Botley West Solar Farm, Deadline 3 Response

22 July 2025

From Mary Ann Canning

AREAS
UNSUITABLE
FOR SOLAR
PANELS

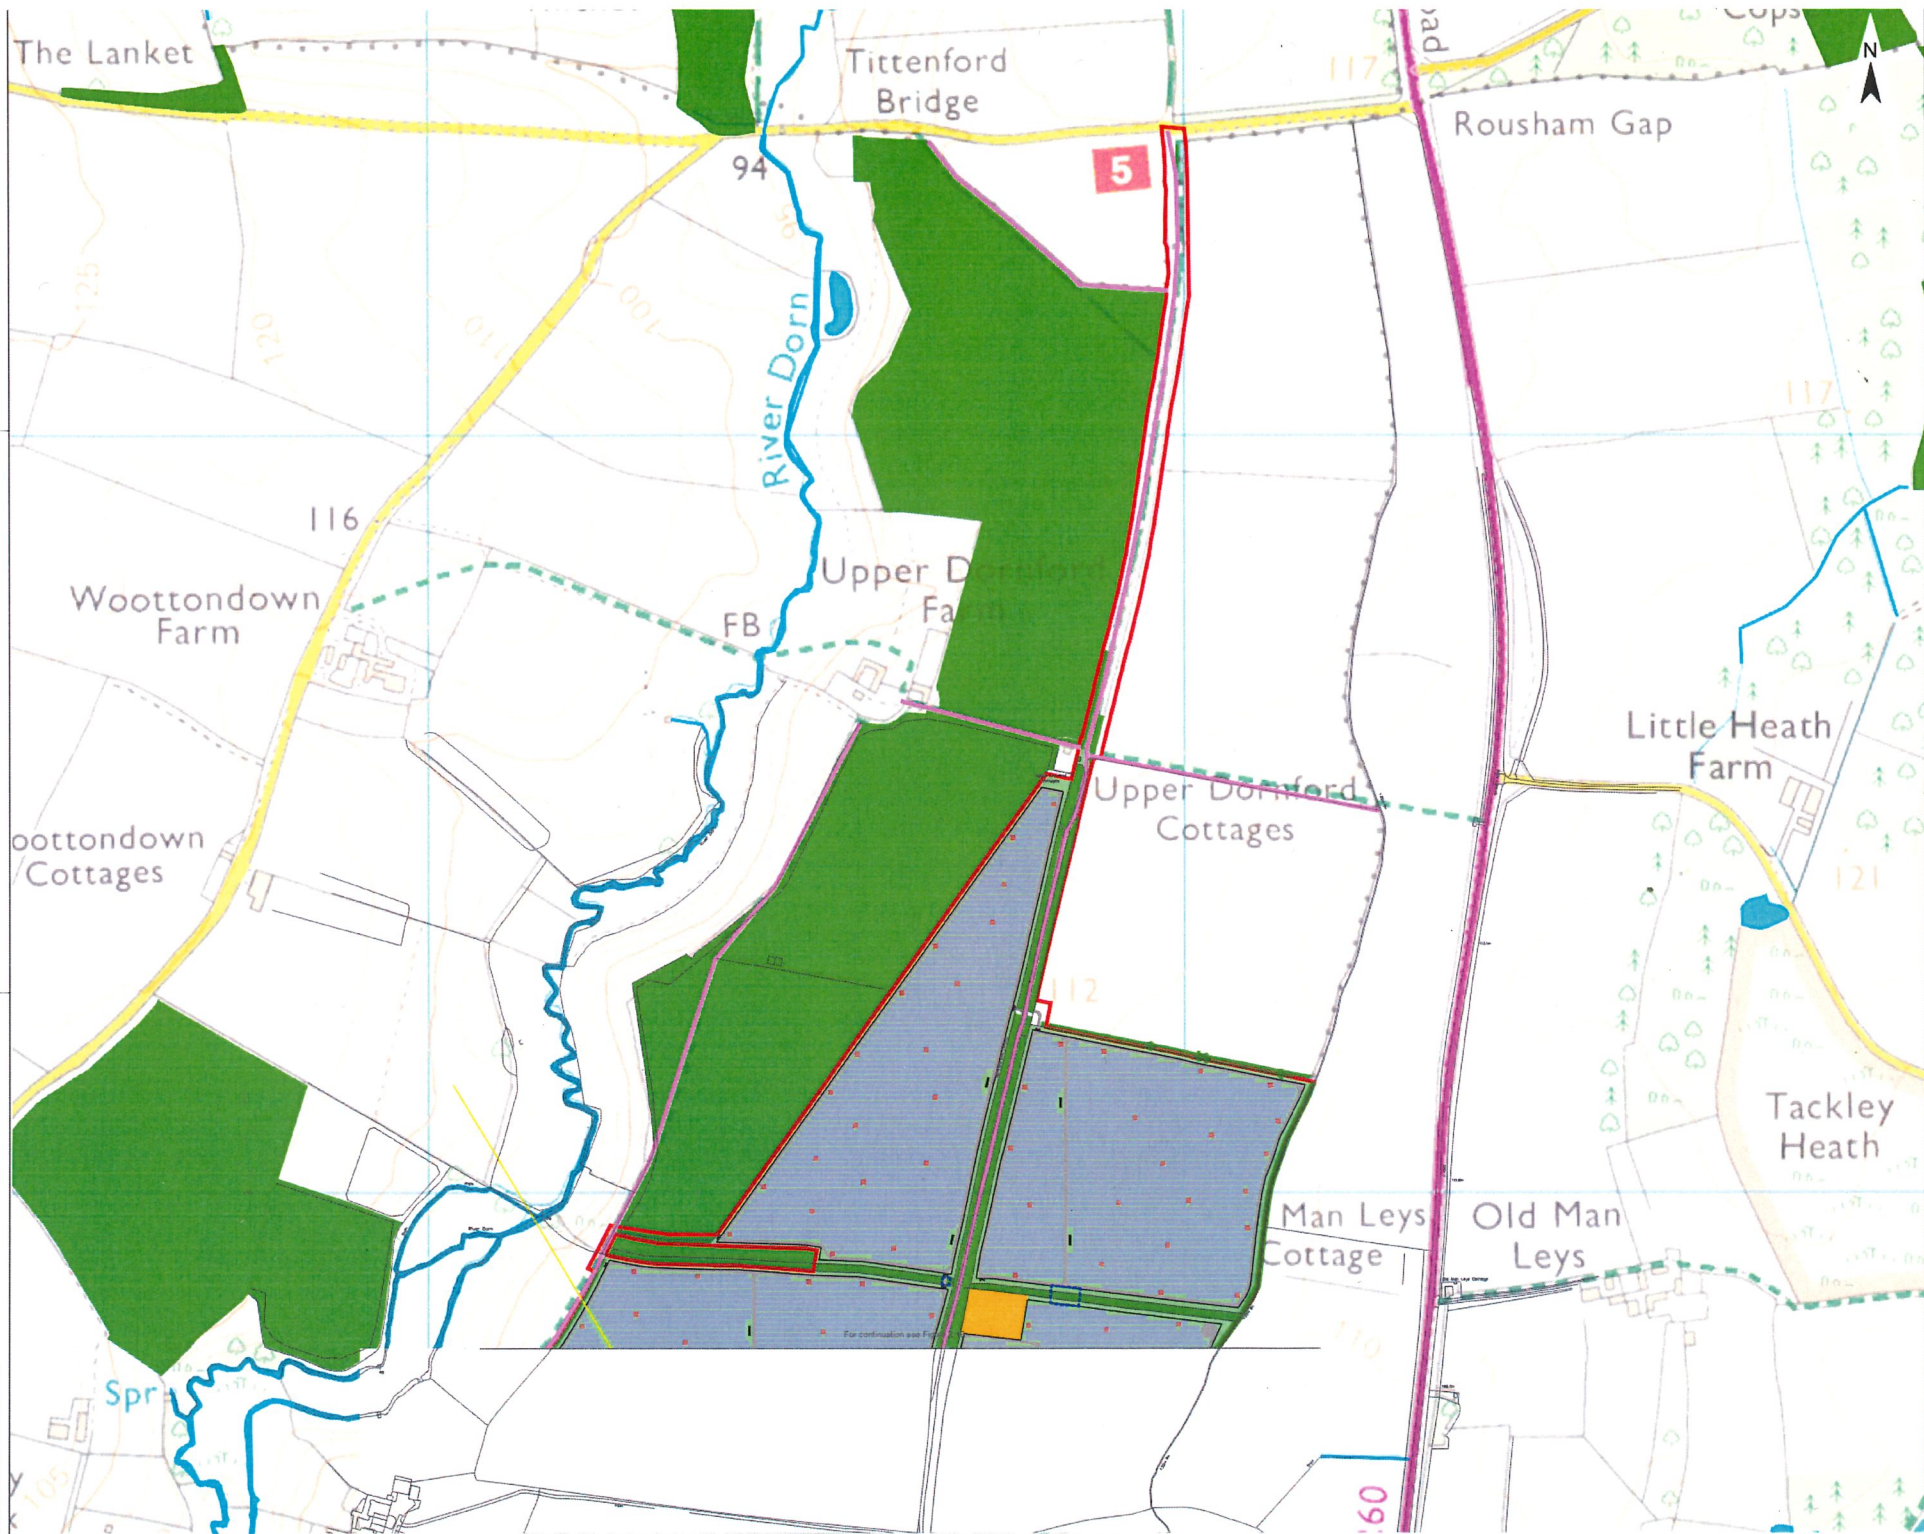
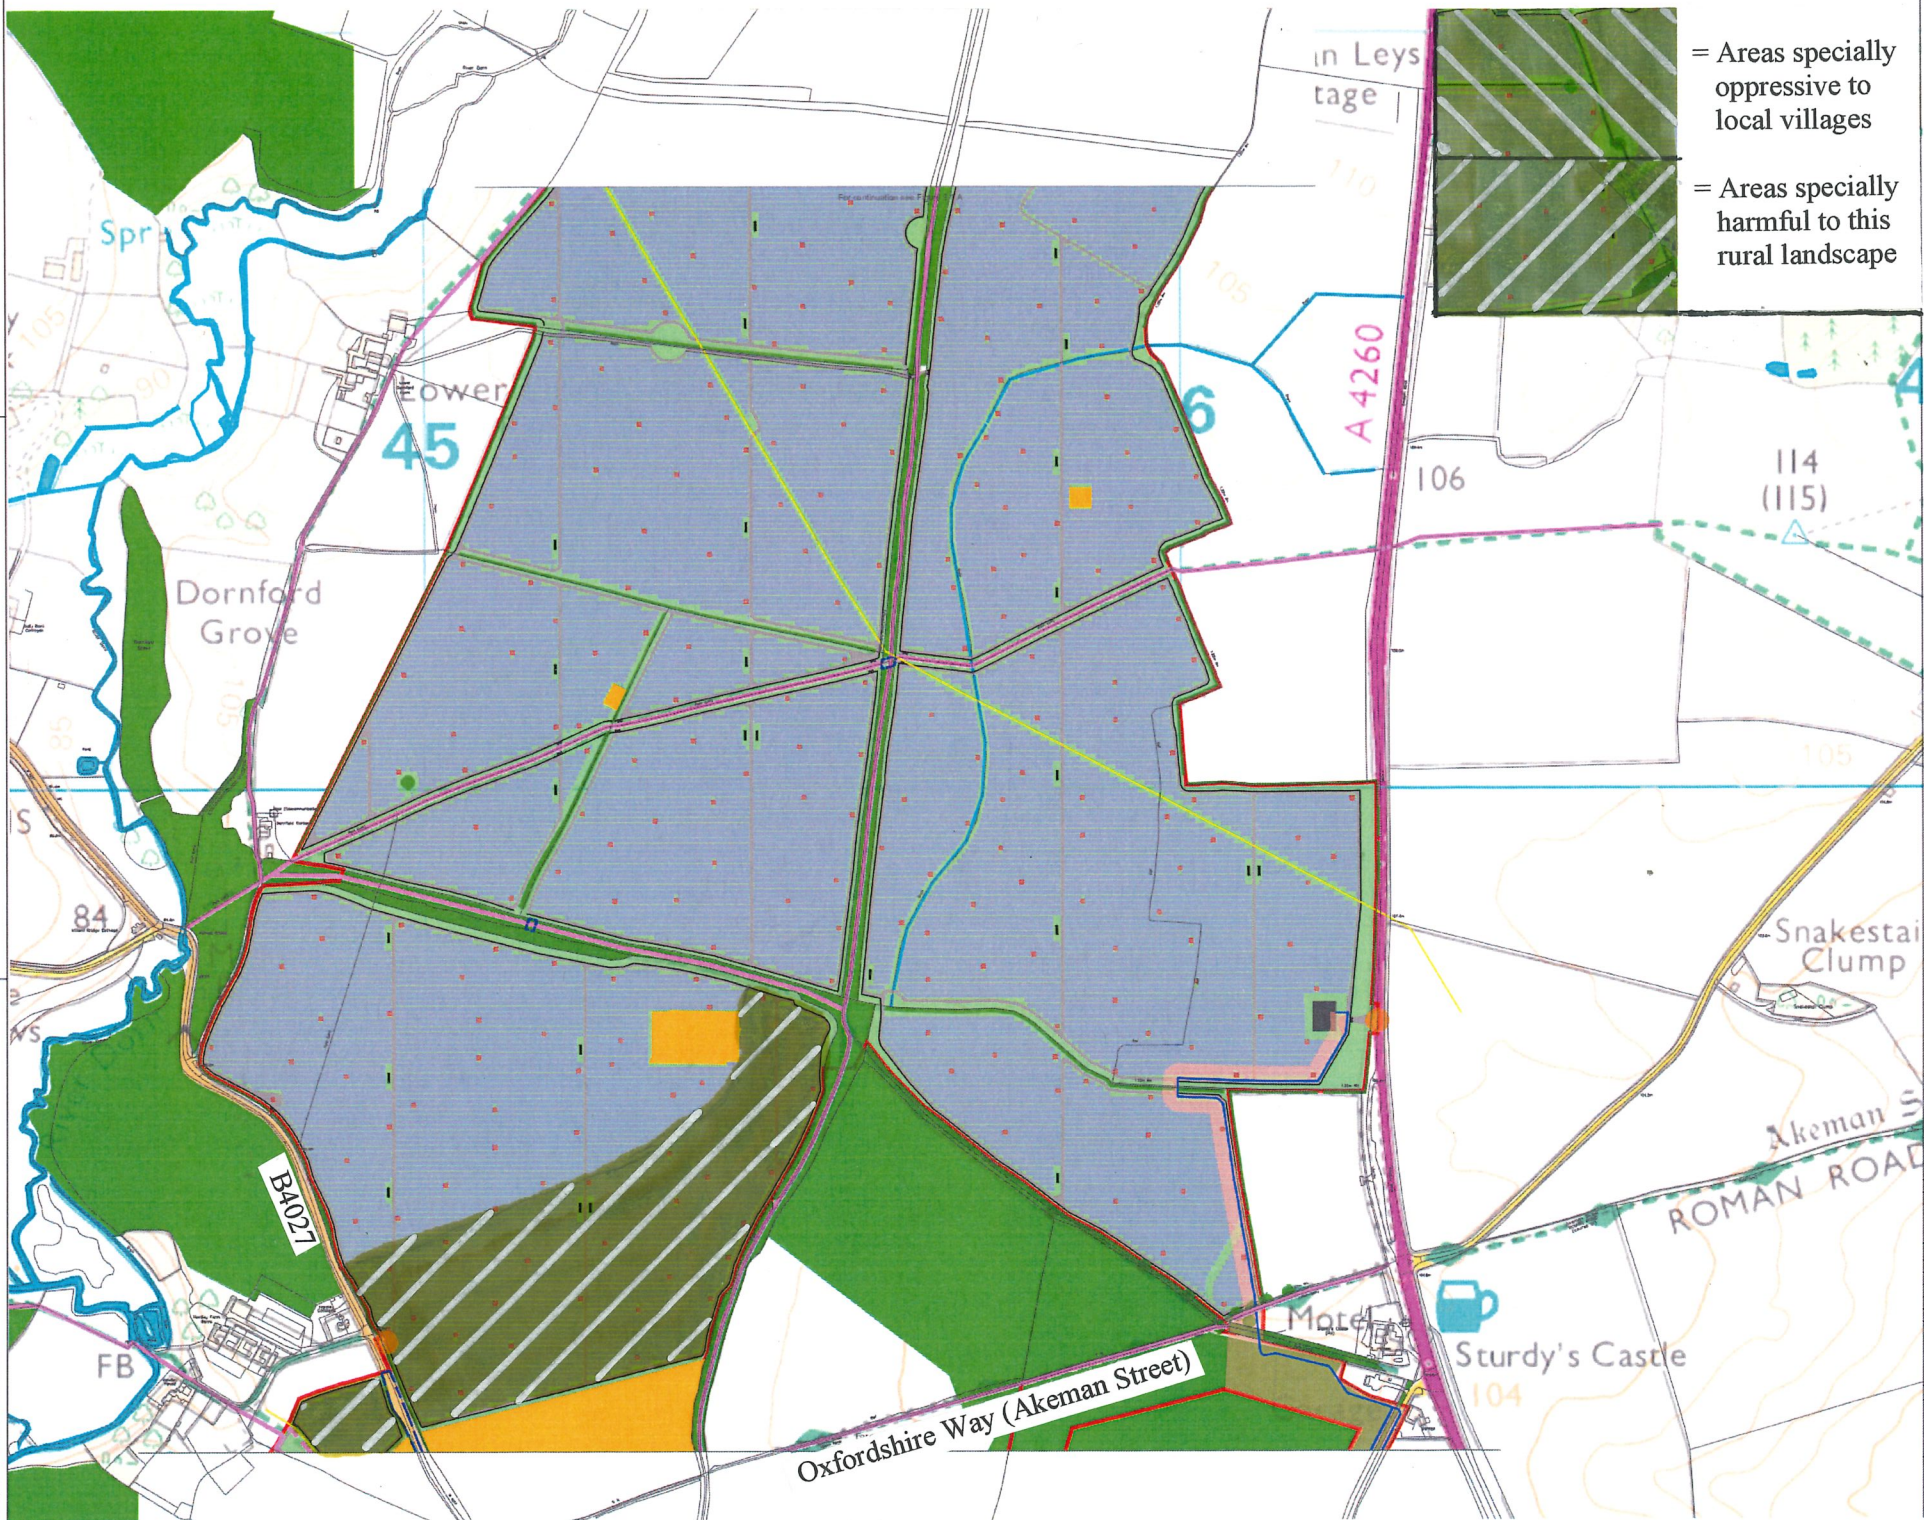
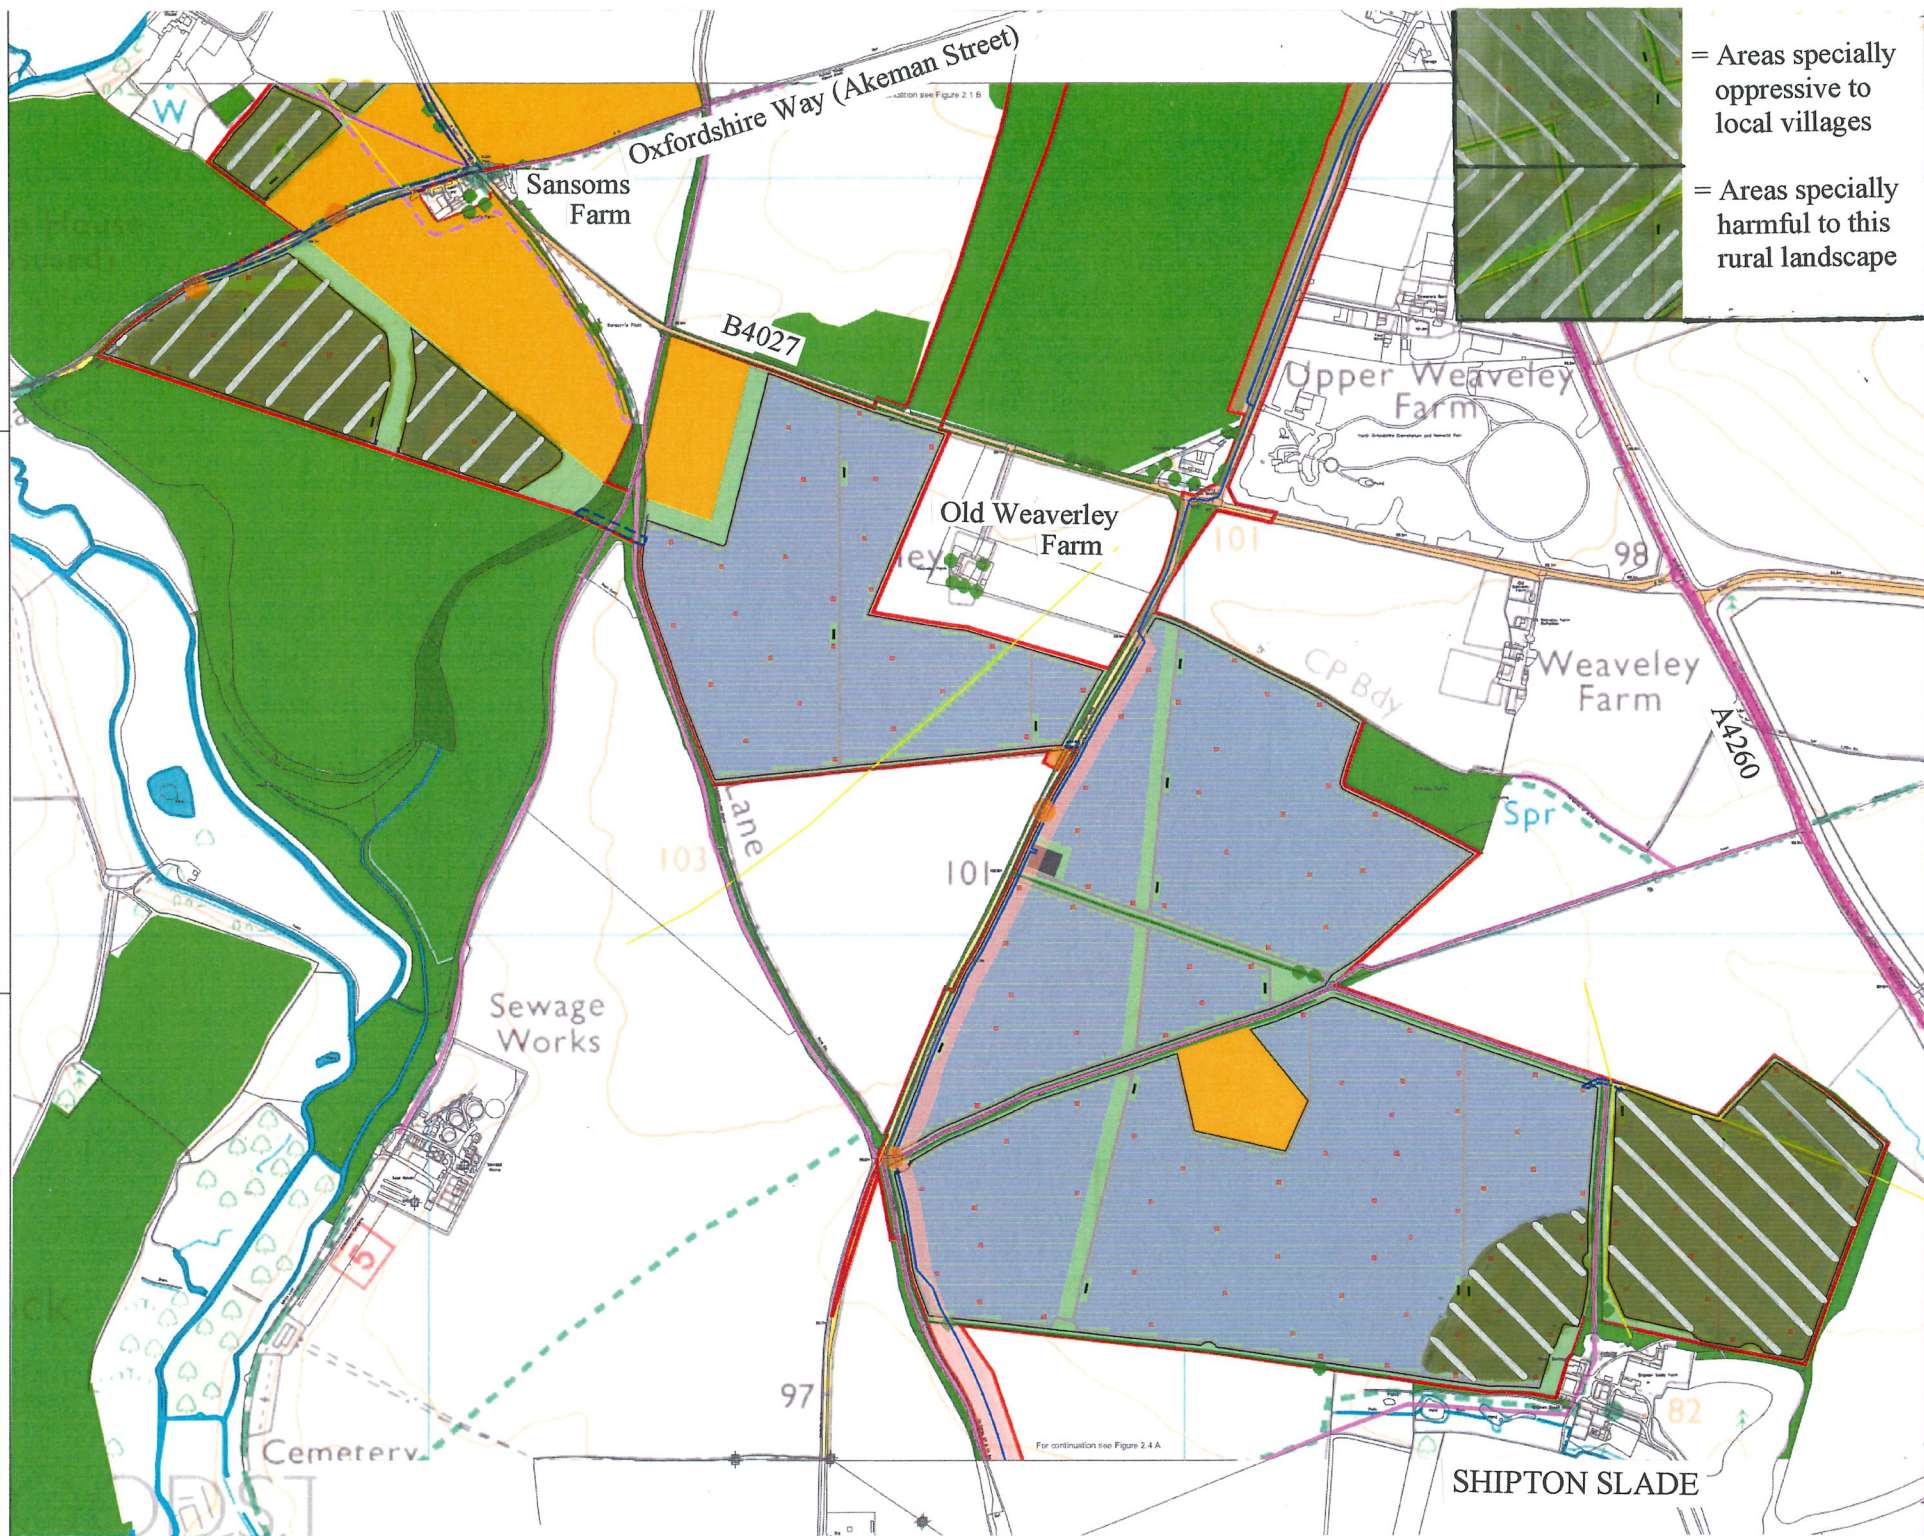
I note that some of these areas have been put forward for omission in EN010147-001239-Applicant's Change Request 2 Notification (Rev 0). However having viewed these (with some difficulty, as the plans aren't clear), I consider they are insufficient to have the required effect, and the escarpment is not included.
